A1 Birtley to Coal House

Statement of Common Ground with Sunderland City Council

The A1 Birtley to Coal House
Development Consent Order 20[xx]

APFP Number:	
Planning Inspectorate Scheme Reference	TR010031
Application Document Reference	TR010031/7.5B
Author:	A1 Birtley to Coal House Project Team, Highways England

Engineering Section Drawings – Regulation 5(2)(o) & 6(2) – Sheet 9 of 9	TR010031/APP/2.5(J)	Rev 0

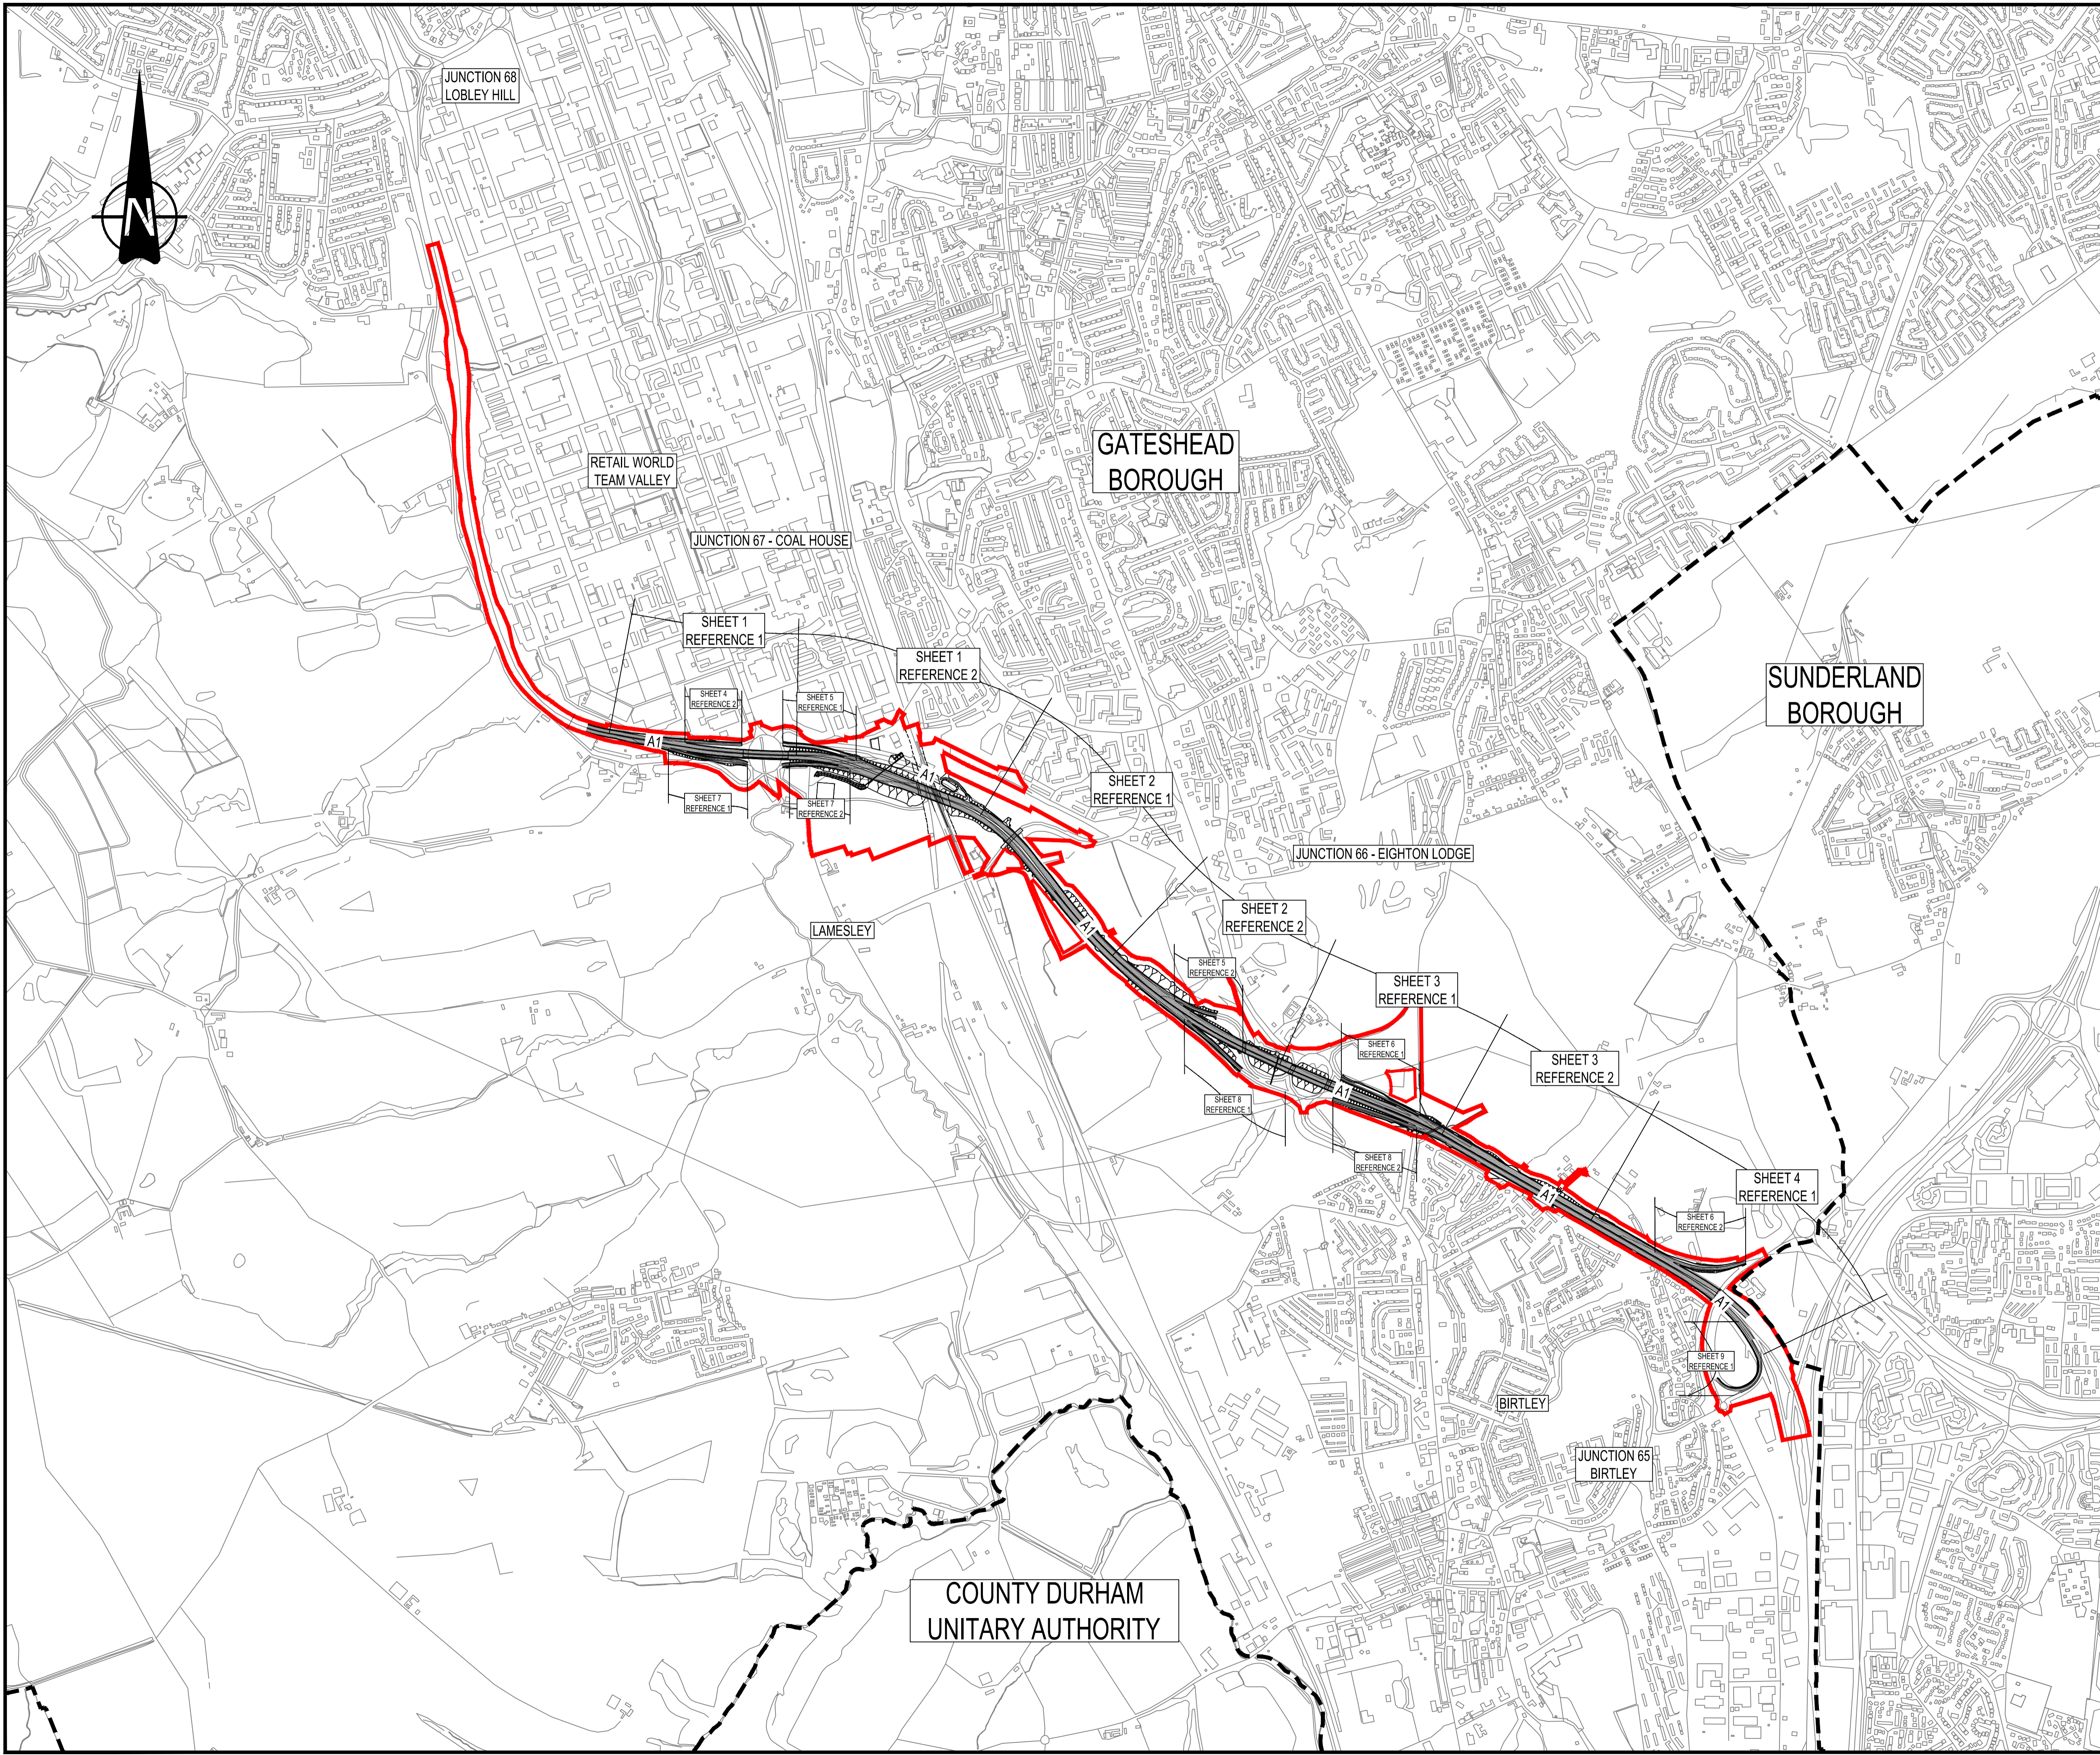
Section	Sub-section	Sunderland City Council Response	Highways England Position	Status
Structures Engineering Drawings and Sections [APP-011]	All	There are some text errors within the submission drawings relating to the naming of local authority areas of Gateshead, Sunderland and Durham which should be corrected. These include reference to 'Sunderland Borough', which should be corrected to 'Sunderland City Council.'	<p>The Proposed Scheme has been detailed in depth in numerous drawings and Sections provided as part of the submission, including the proposed design of:</p> <ul style="list-style-type: none"> · The Viaduct and Embankment Options · Ramp at North Dene Footbridge · Lighting of the underpass · Public Rights of Way diversions. <p>Plans are being updated to correct errors identified.</p>	Under Discussion
